OXFORDSHIRE COUNTY COUNCIL'S RESPONSE TO CONSULTATION ON THE FOLLOWING DEVELOPMENT PROPOSAL

Application no: 22/00747/OUT

Proposal: Outline planning application for the development of up to 370 homes, public open space (including play areas and woodland planting), sports pitches and pavilion, drainage and engineering works, with all matters reserved (appearance, landscaping, layout and scale) except for vehicular and emergency accesses to Bicester Road.

Transport Schedule

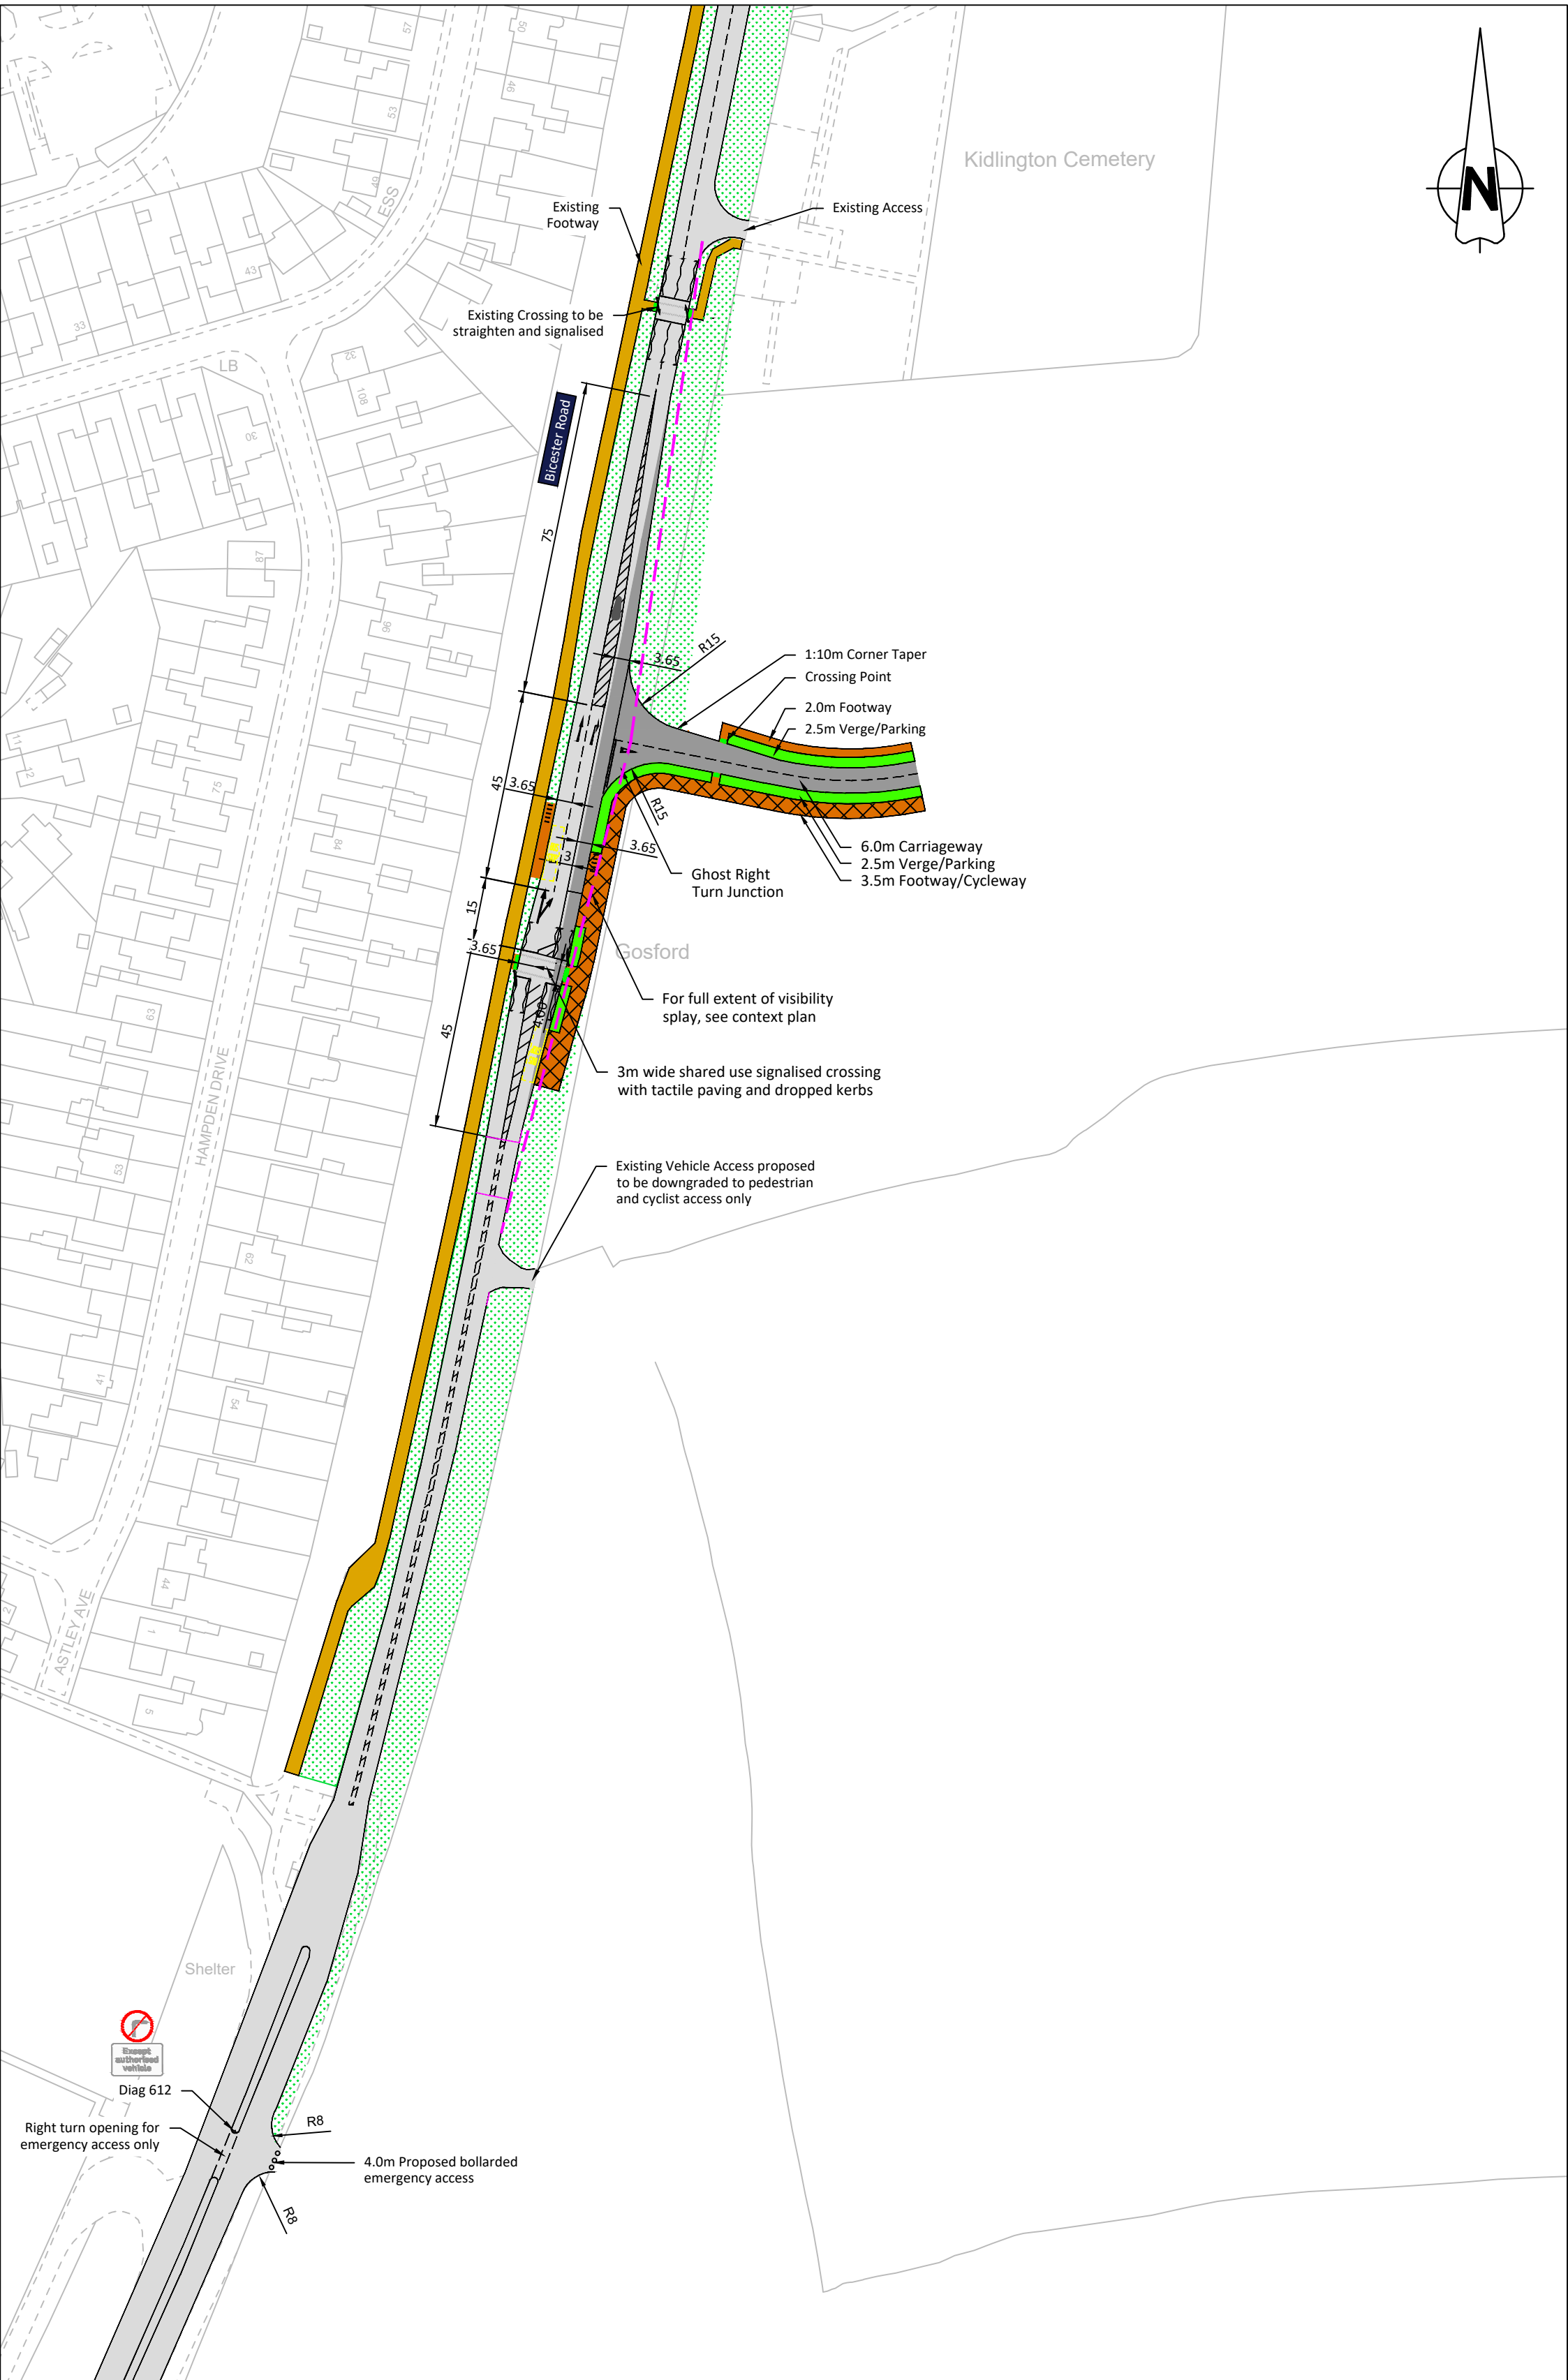
The current submission further illustrates how the Greenway and the PRow are likely to tie into the shared pedestrian/ cycle infrastructure along Oxford Road. The detail of this linkage and proposed infrastructure along Oxford Road is not consistent with standards set out in LTN1/20 and shall need to be agreed to with the County. In the County's previous response, it was requested that provisions consistent with what PR6a and PR6b are proposing along the corridor south of the A34 bridge which may require some land to be dedicated along the development's frontage. The TN acknowledges that this shall be addressed with the s106.
